RE: 10509 Steward St NW
Request for Certificate of Occupancy – Permanent
Engineer's Certification – Not Accepted
Grading Plan Stamp Date 2/20/18
Engineer's Certification Date: 11/13/18
Hydrology File: A12D029

Project Title: 10509 STEWARD ST. NW G+D Building Permit #: _____ City Drainage #: _____

**GRADING & DRAINAGE PLAN**  
**10509 Steward St, NW**  
**LOT 8, BLOCK 16, PARADISE HTS**  
**UNIT ONE**

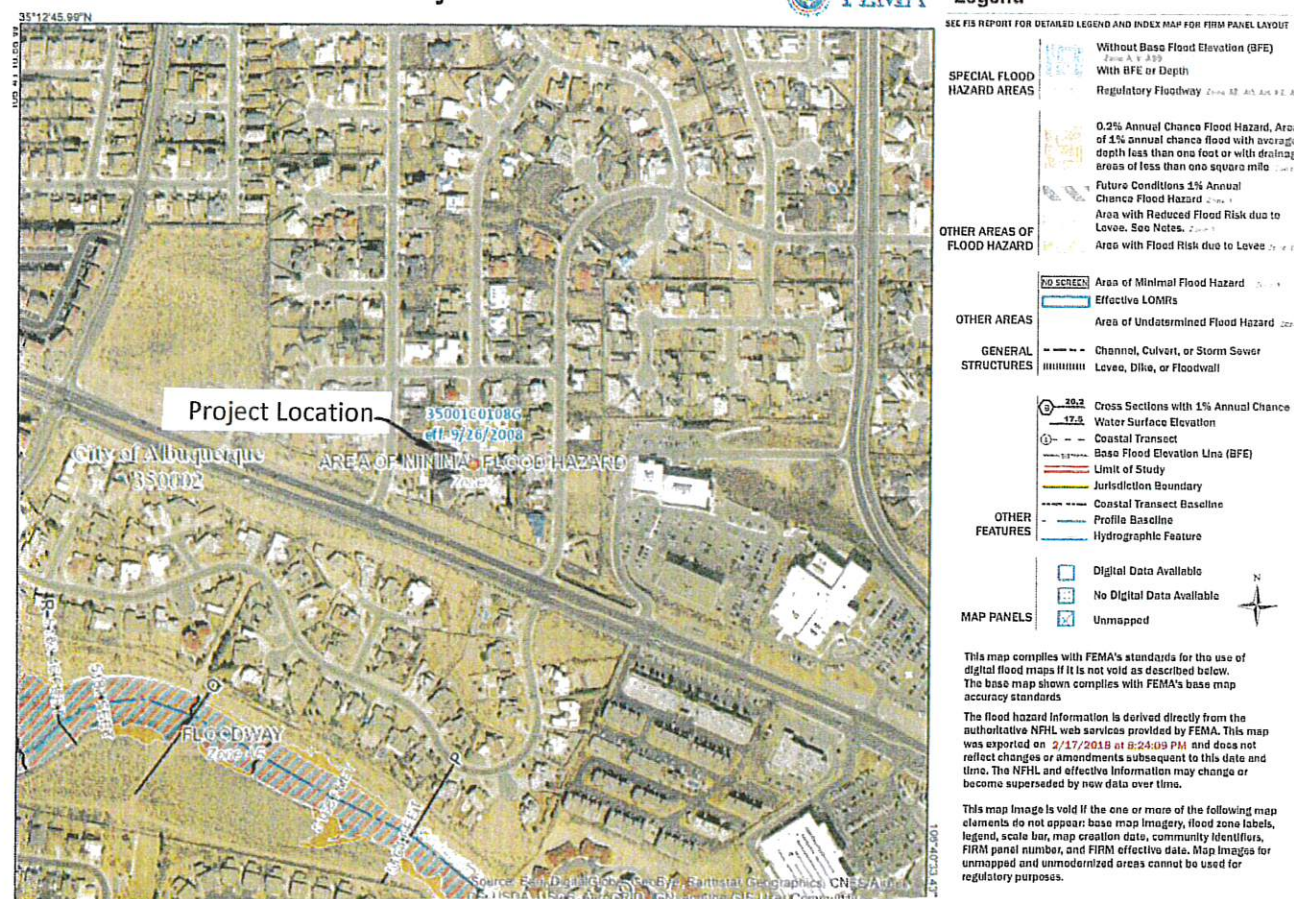
1. The exposed footer and bottom course of CMU block need to be reburied along the north property line:

2. Remove the rock pile from the public ROW:
